04/11/2020

**Western Sydney University Bankstown City Campus (SSD-9831)
Request for Additional Information**

I refer to the Amended Development Application (DA) and Response to Submissions (RtS) for the Western Sydney University Bankstown City Campus (SSD-9831). After careful consideration, the Department is requesting that you provide additional information.

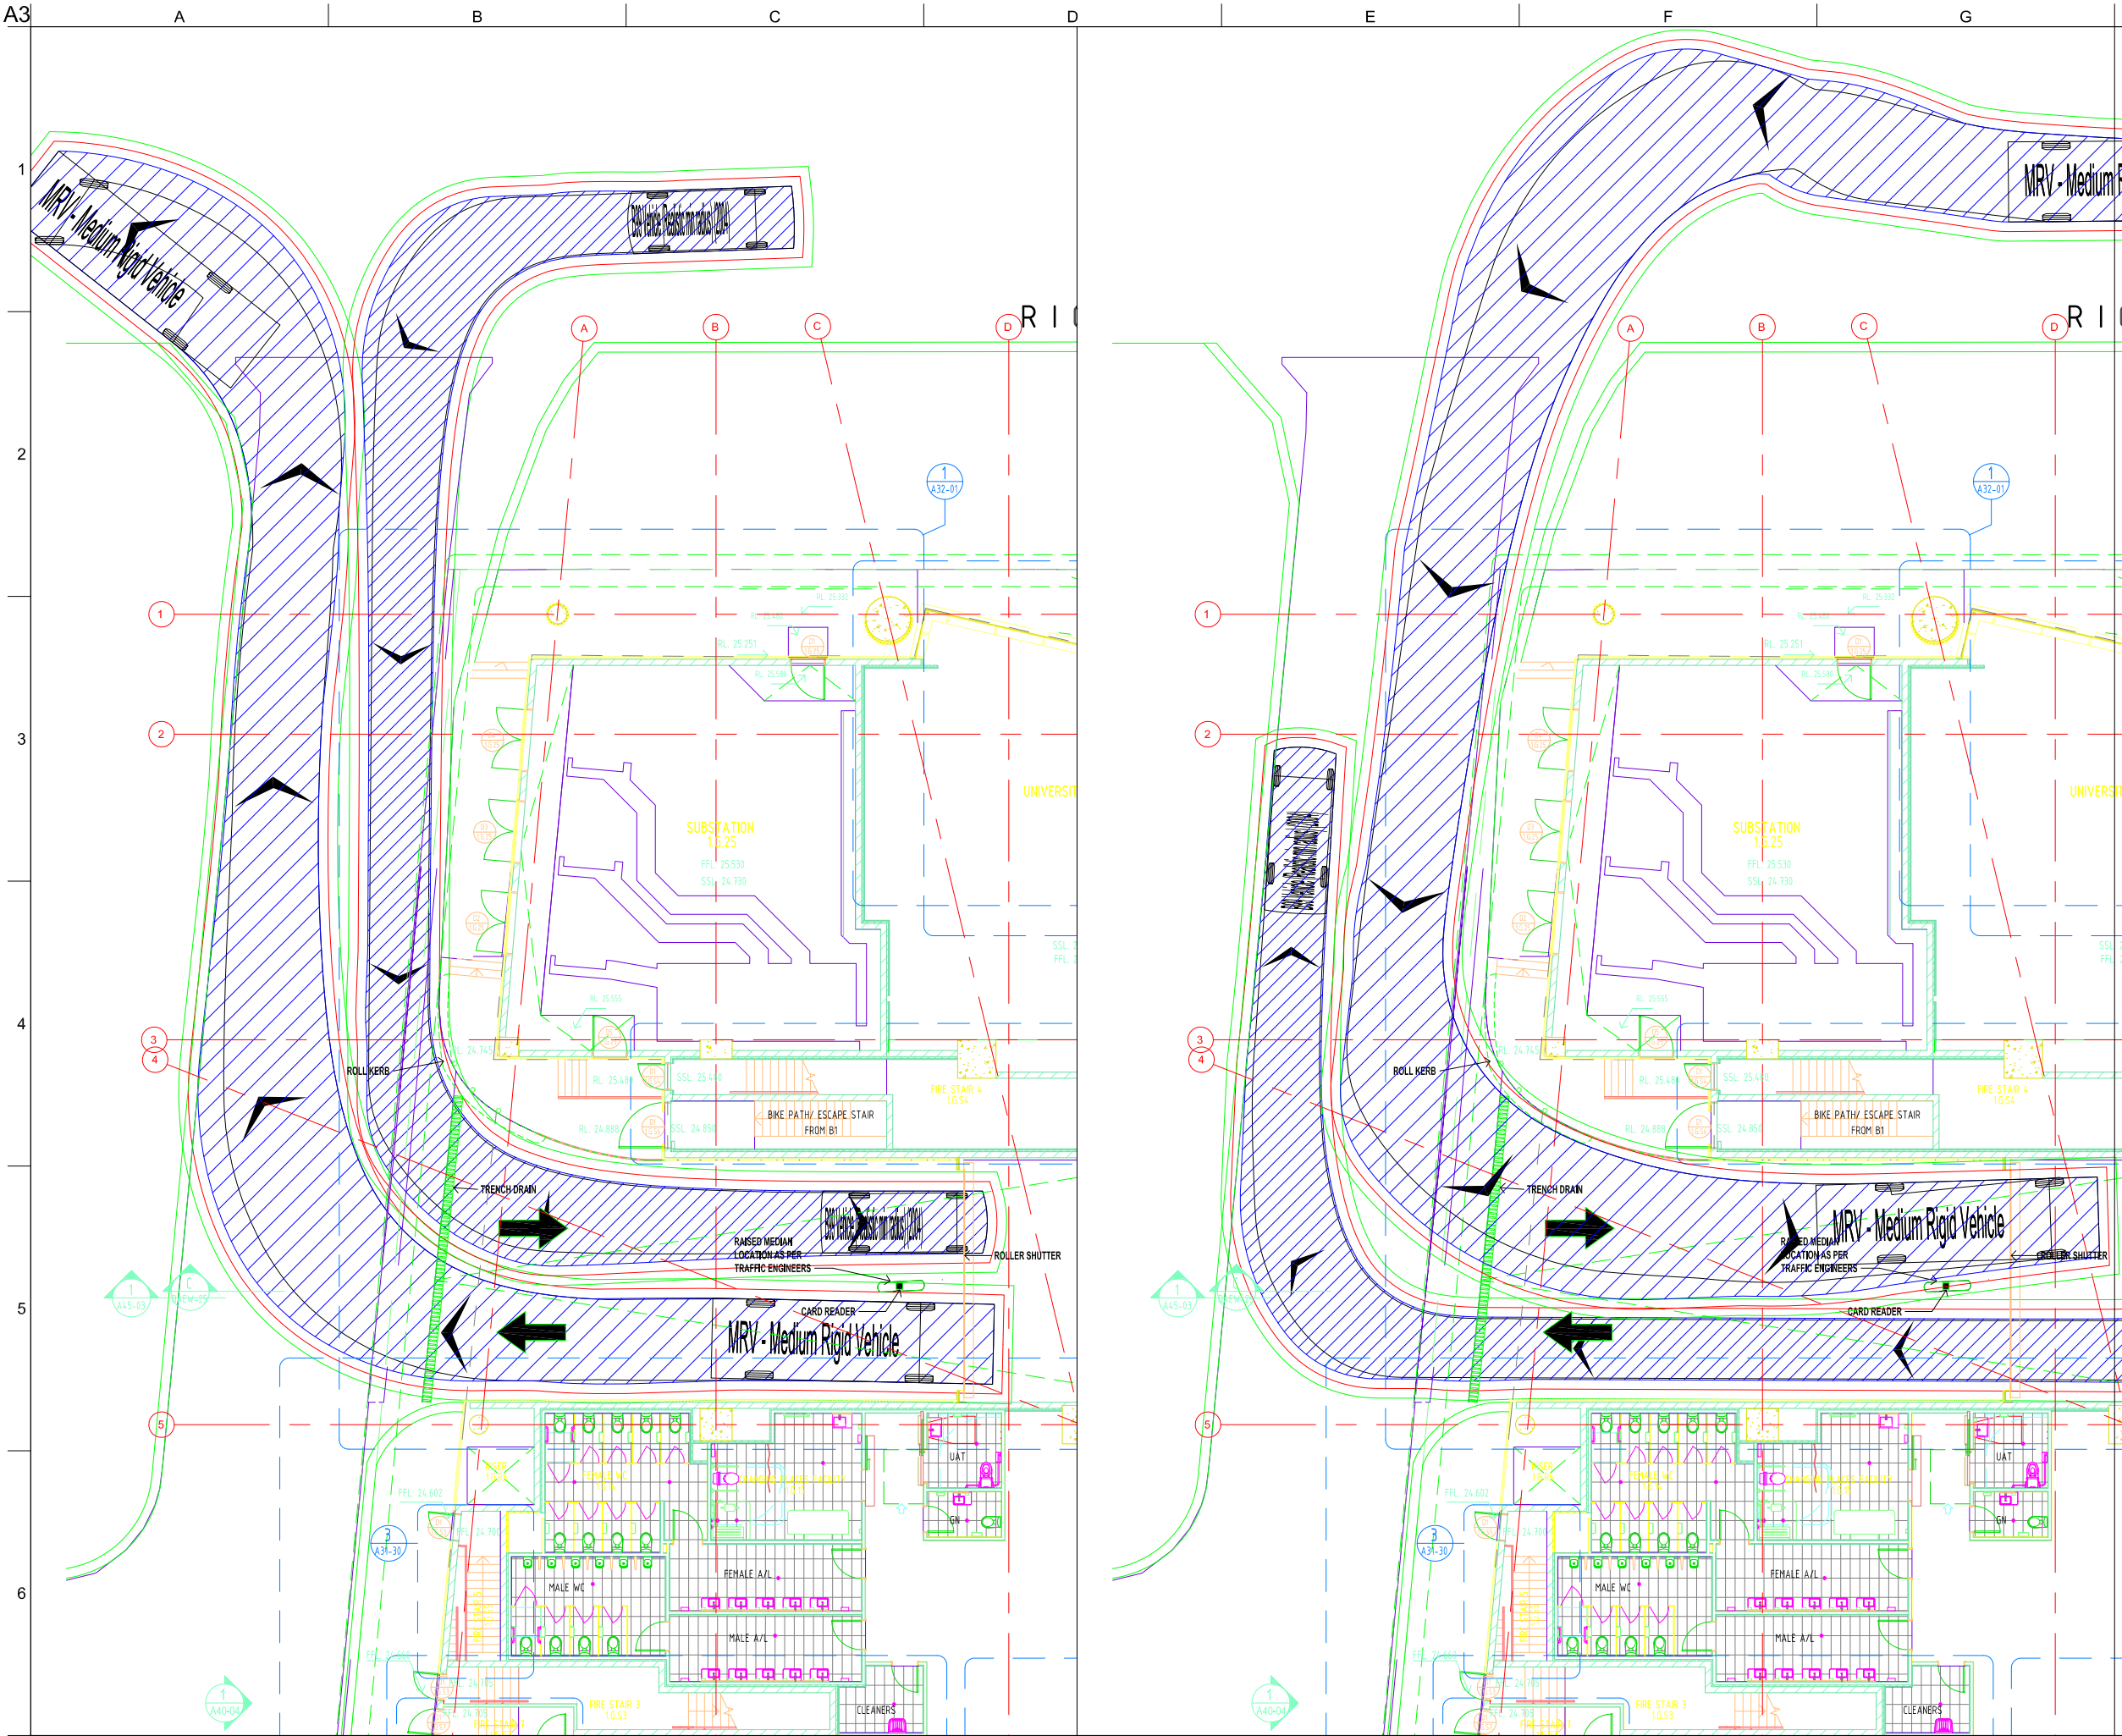
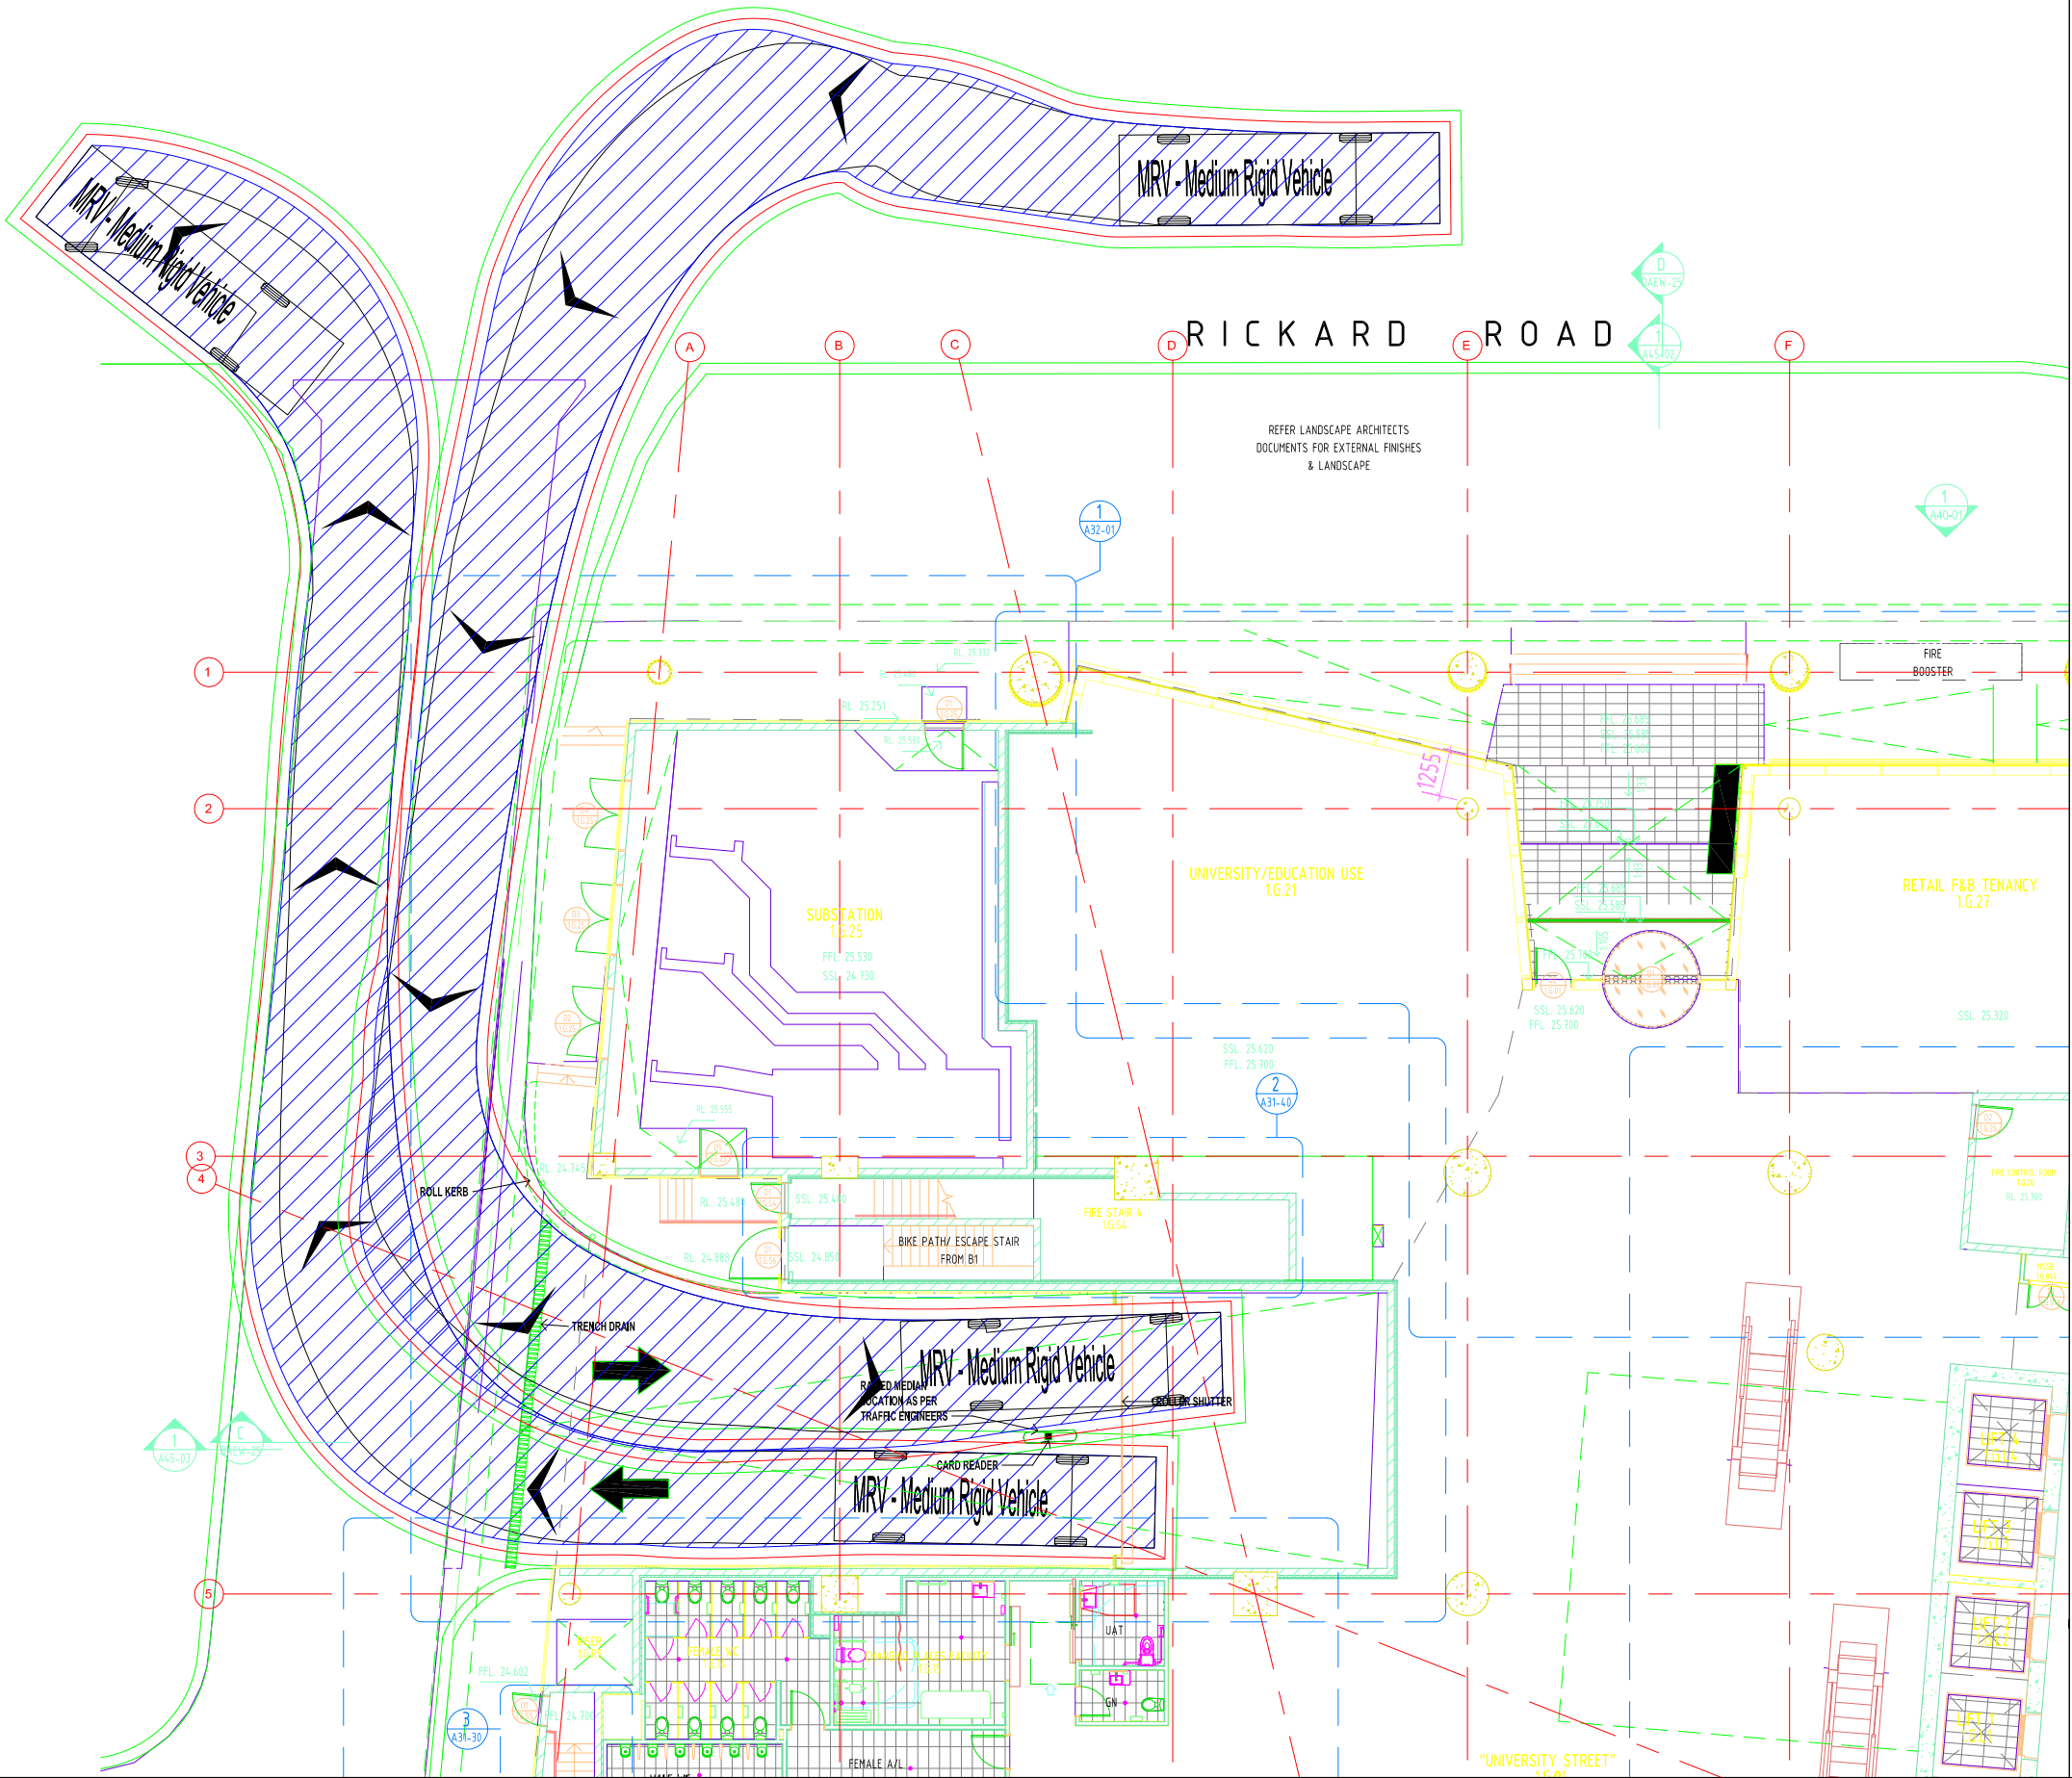
- Provide updated information to address medium rigid vehicle (MRV) access to the basement loading dock via the adjoining driveway, including:
 - all turning path diagrams should be updated to correctly show all kerbs and travel lanes as well as any proposed median islands or infrastructure.
 - address the potential for vehicular conflicts between exiting and entering vehicles, particularly MRVs.
 - demonstrate adequate clearance is provided for MRV access in accordance with AS2890.2.
- Provide updated information to address access to The Appian Way, including:
 - all turning path diagrams should be updated to correctly show all kerbs and travel lanes.
 - address access to Council's loading bay.
 - address Council's requirement for heavy rigid vehicle access and egress.
